Pagham Parish Council
C C Braby
Village Hall
Pagham Road, Pagham
West Sussex
PO21 4NJ

28th July 2011

Single storey extensions
52 East Front Road Pagham

Thank you for your internet representation made on 27th July 2011 which has been recorded as **an objection** with the comments as follows:

For	Date	Dwg by	Revision
Mr and Mrs Evers	24.05.2011	sk	C
Title	Scale	Project no	Dwg no
PROPOSED LAYOUT, ELEVATIONS AND SECTION A-A	1:50	126	P2

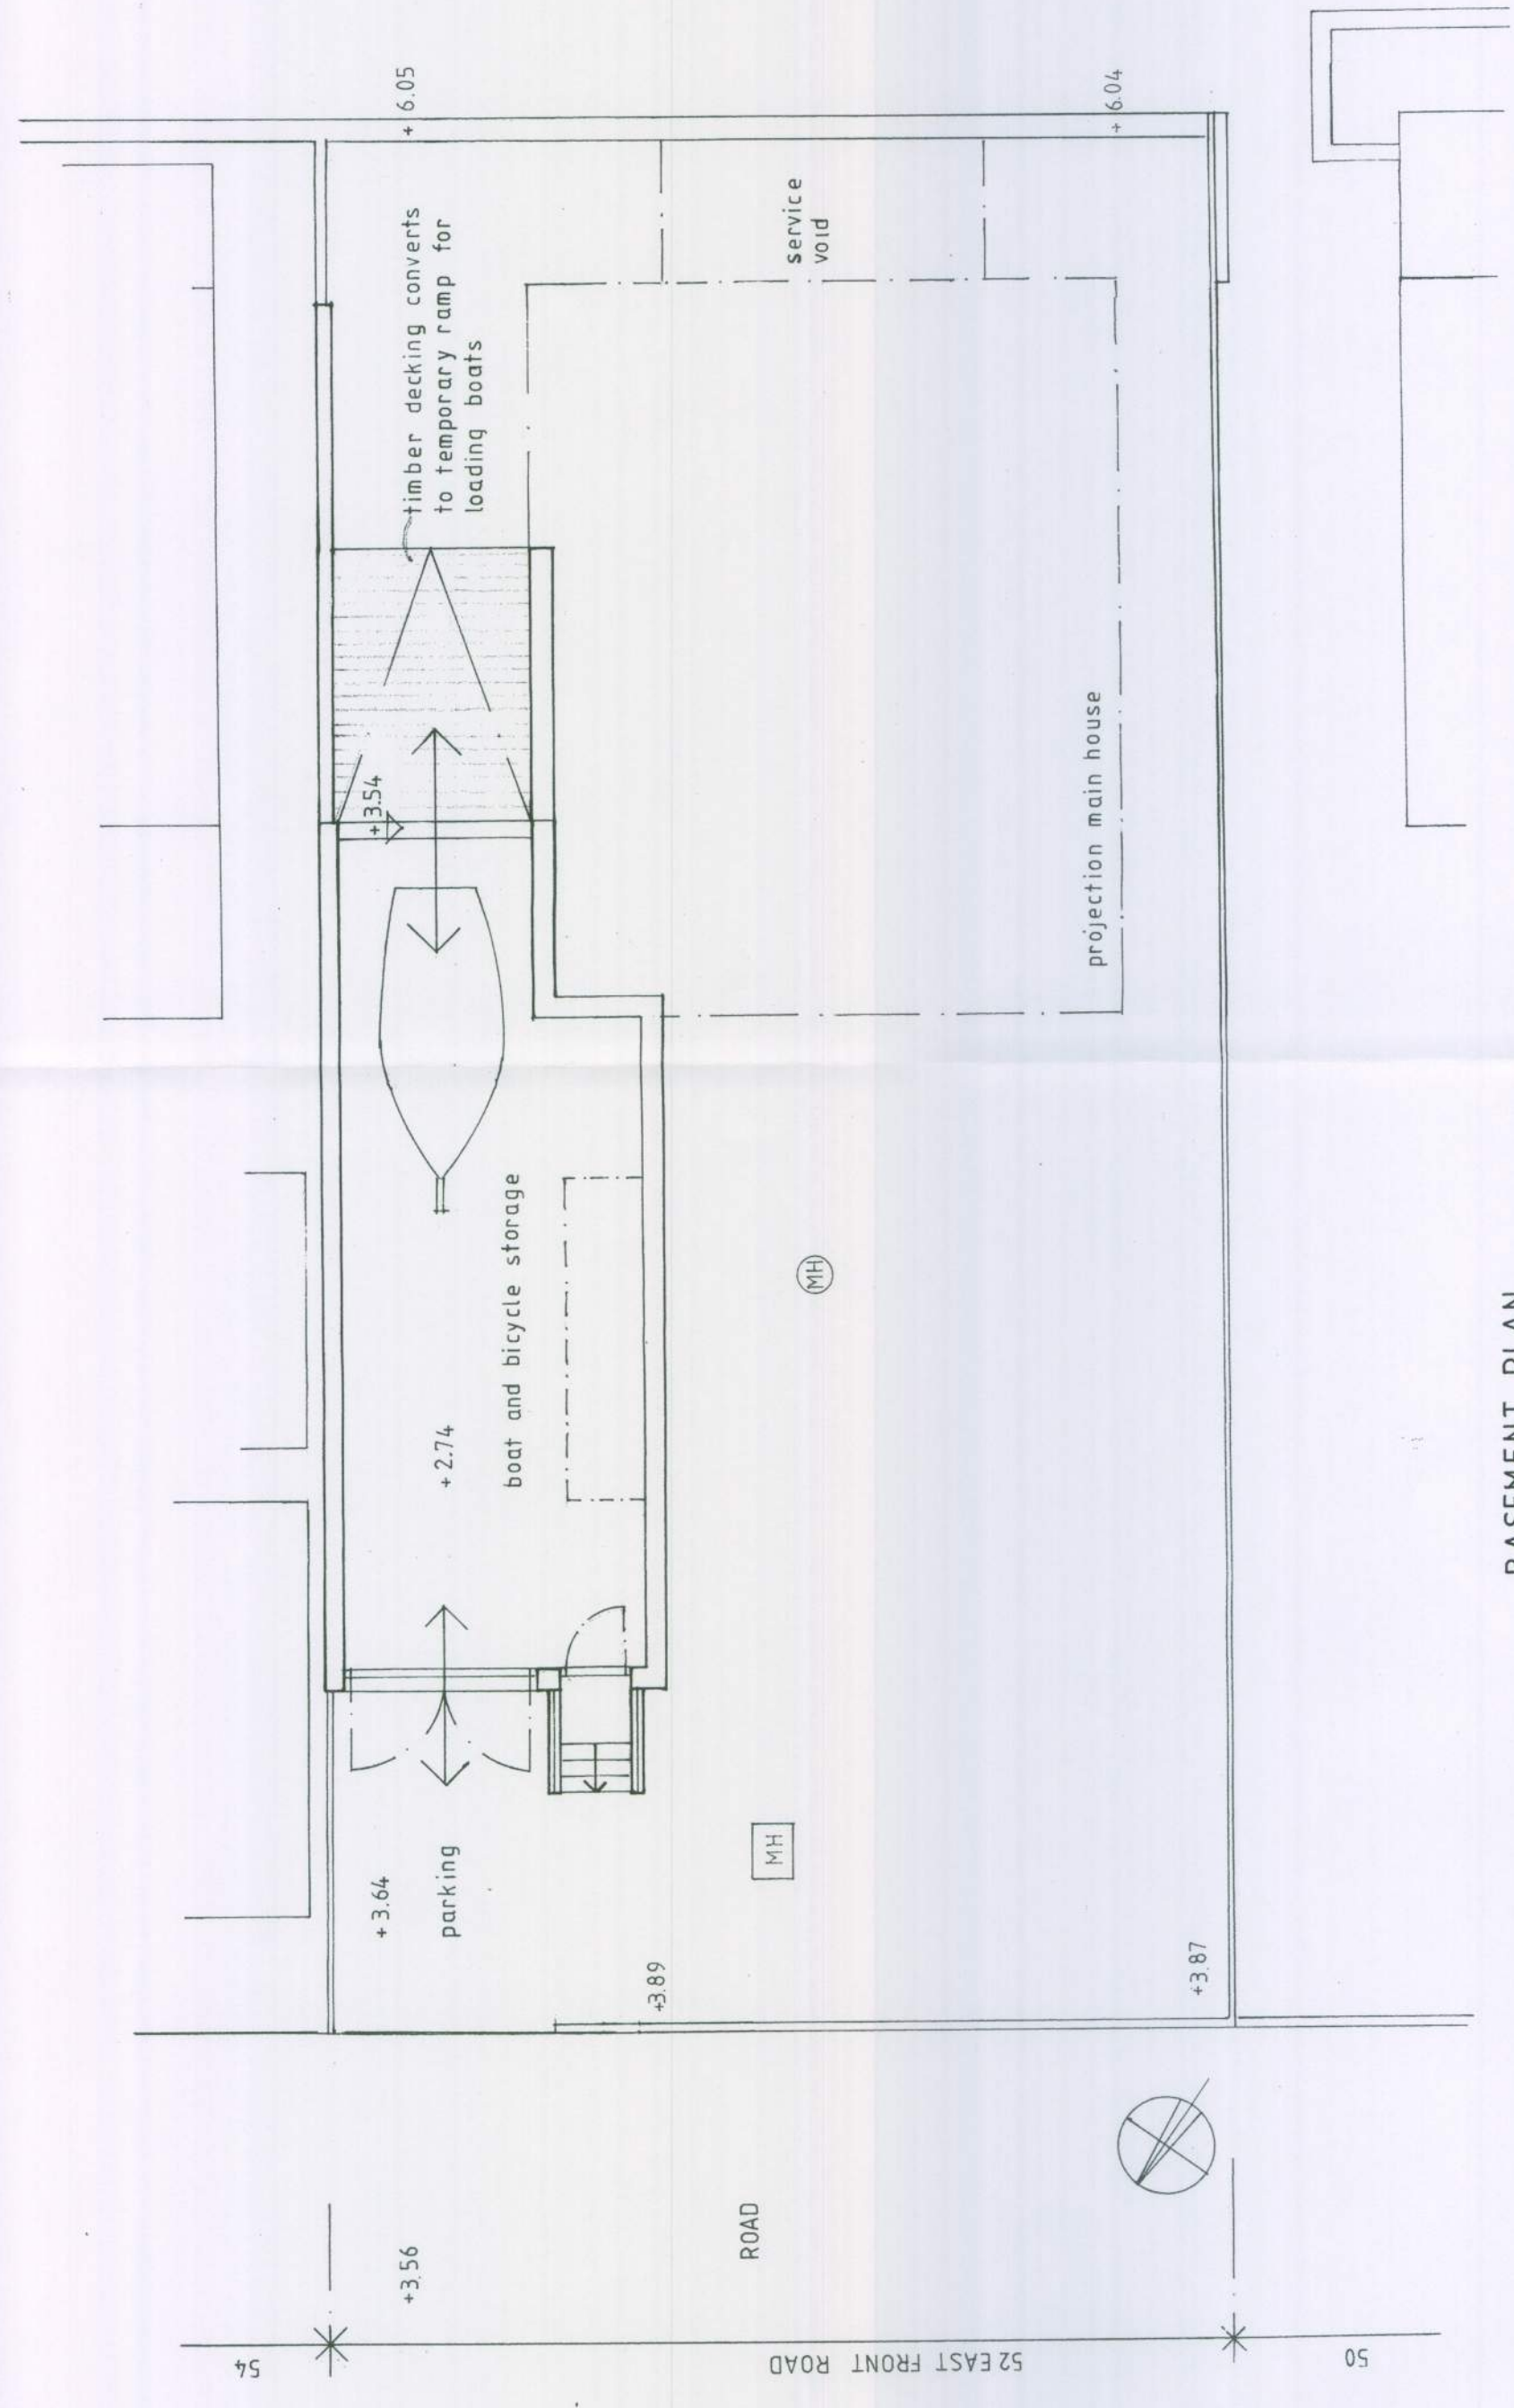
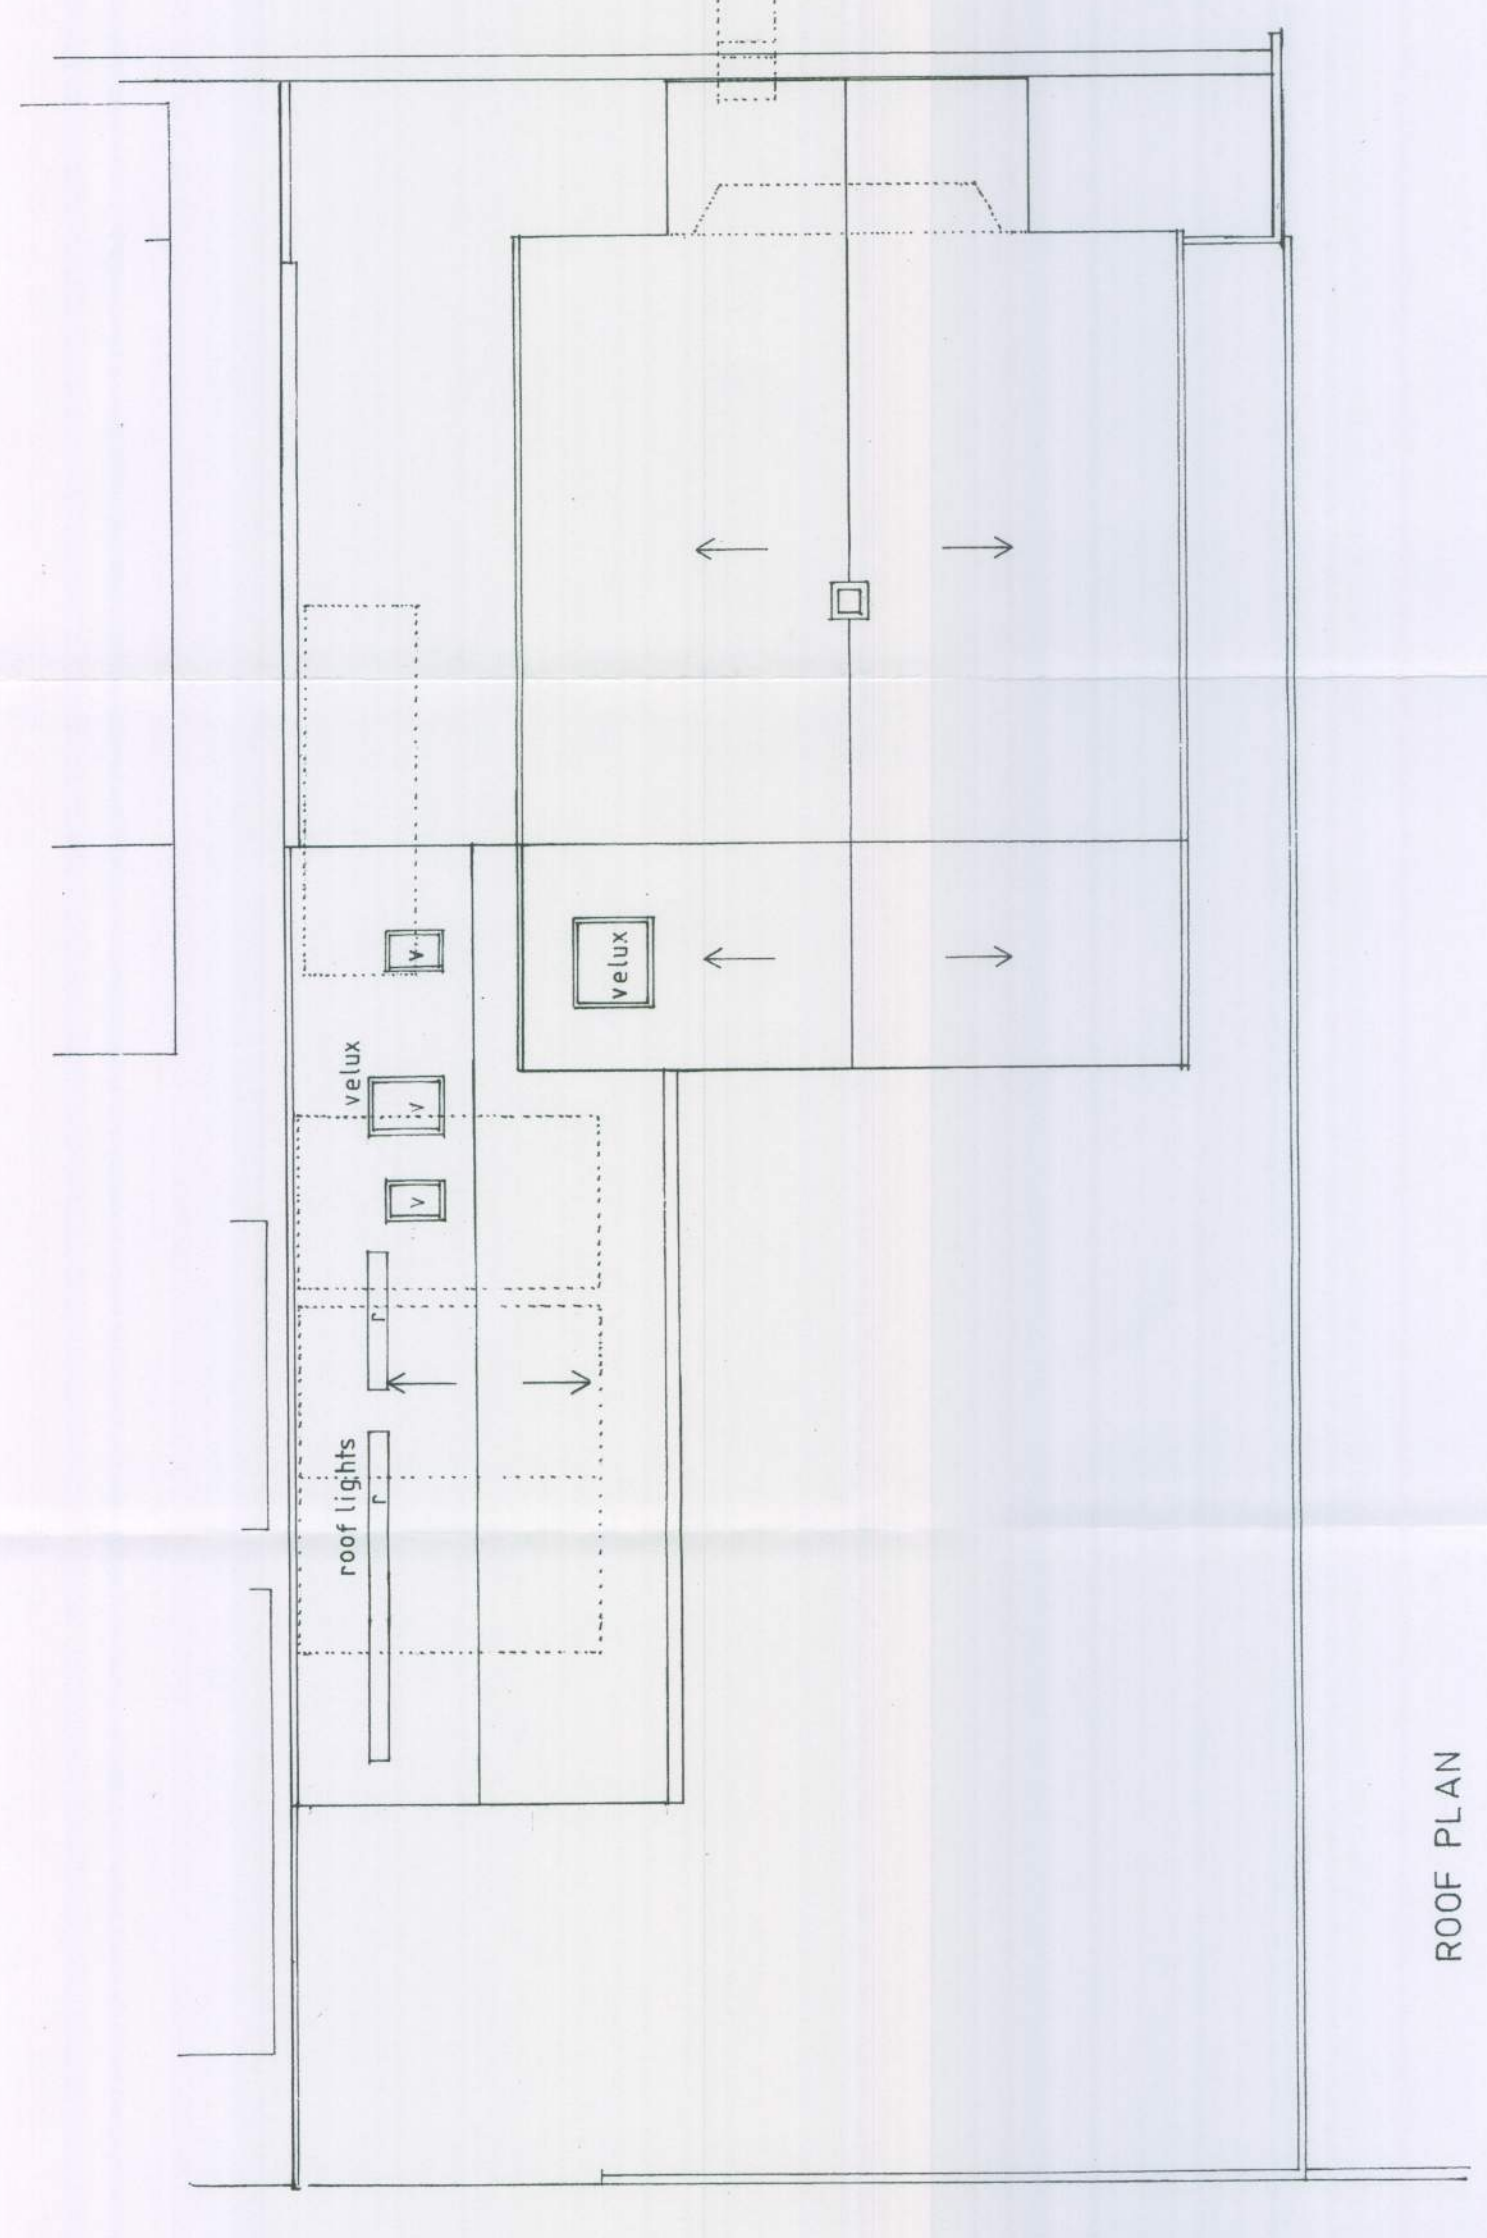
The prospect of engineering a very large excavation in order to accommodate a proposed underground room was viewed as particularly contentious from the point of potential extreme prejudice to dwellings adjacent where existing foundations systems would be put at risk of shingle subsidence and consequential collapse. ☐
